**From:** Gregg, Robert <Robert.Gregg@lancashire.gov.uk>  
**Sent:** 17 February 2021 14:12  
**To:** Ben Taylor; Planning; LHS Customer Service  
**Subject:** D3.2021.0013 - School House Farm

Looking at the Proposed two storey extension above the garage and conversion of the attic into a master bedroom, whilst I would raise no objection to the principle of the development proposal, I must be satisfied that all highway concerns have been taking into consideration and therefore my initial comments would allow the applicant the opportunity to address the below raised concern.

Mr N Fielding	
Proposed Alterations School House Farm Osbaldeston Lane Osbaldeston	
Existing Site Plan	
1:100	29.12.20 PD
1210 - 101	-

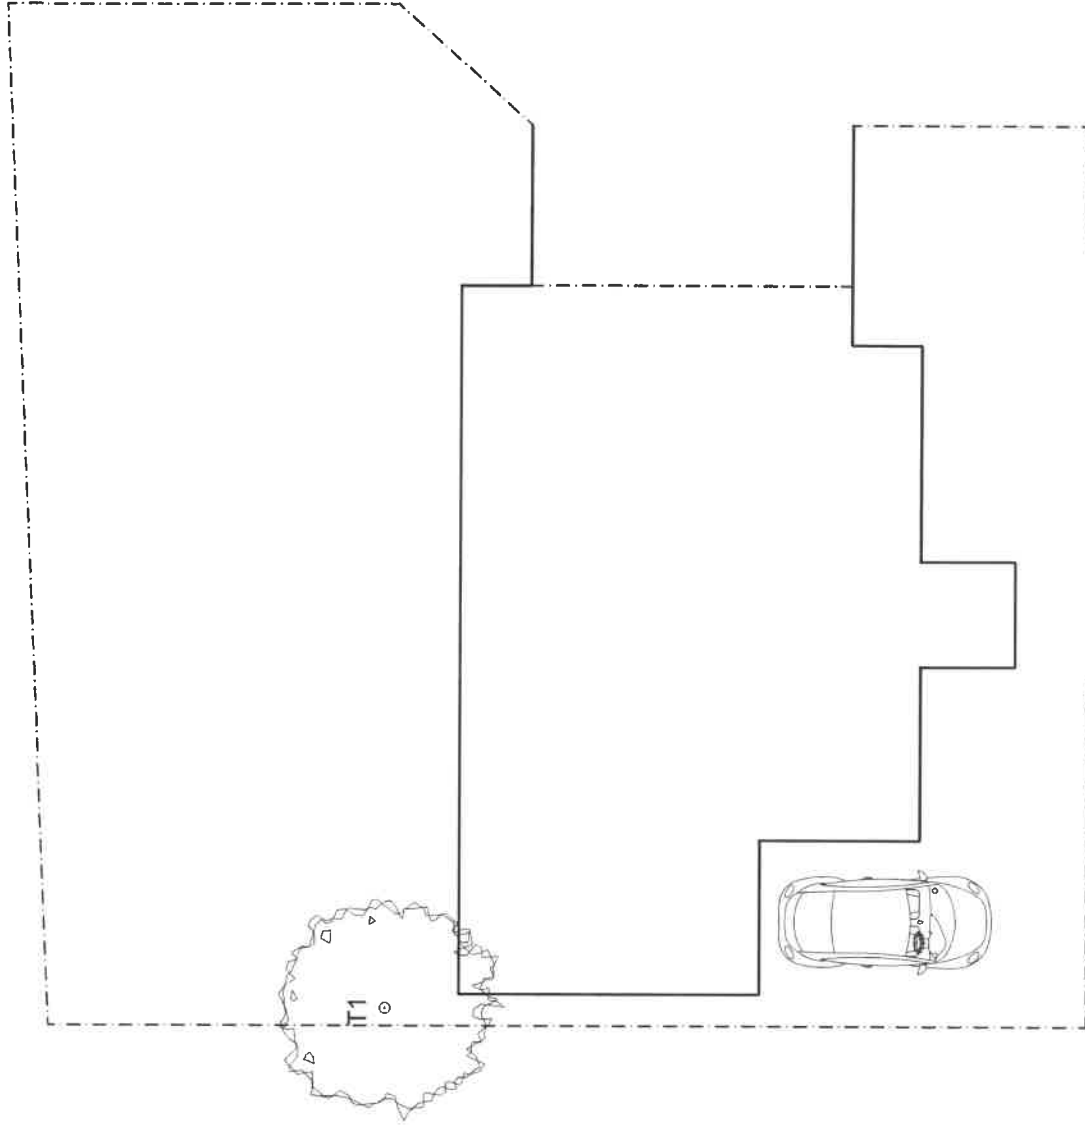
There will be an increase to the existing number of bedrooms from three to four which will see a maximum parking provision of three parking spaces. Due to the nature of the road and the developments rural location three off-street parking spaces will be required within the curtilage of the property.

Can I ask that the applicant reflects this within an amended site layout drawing.
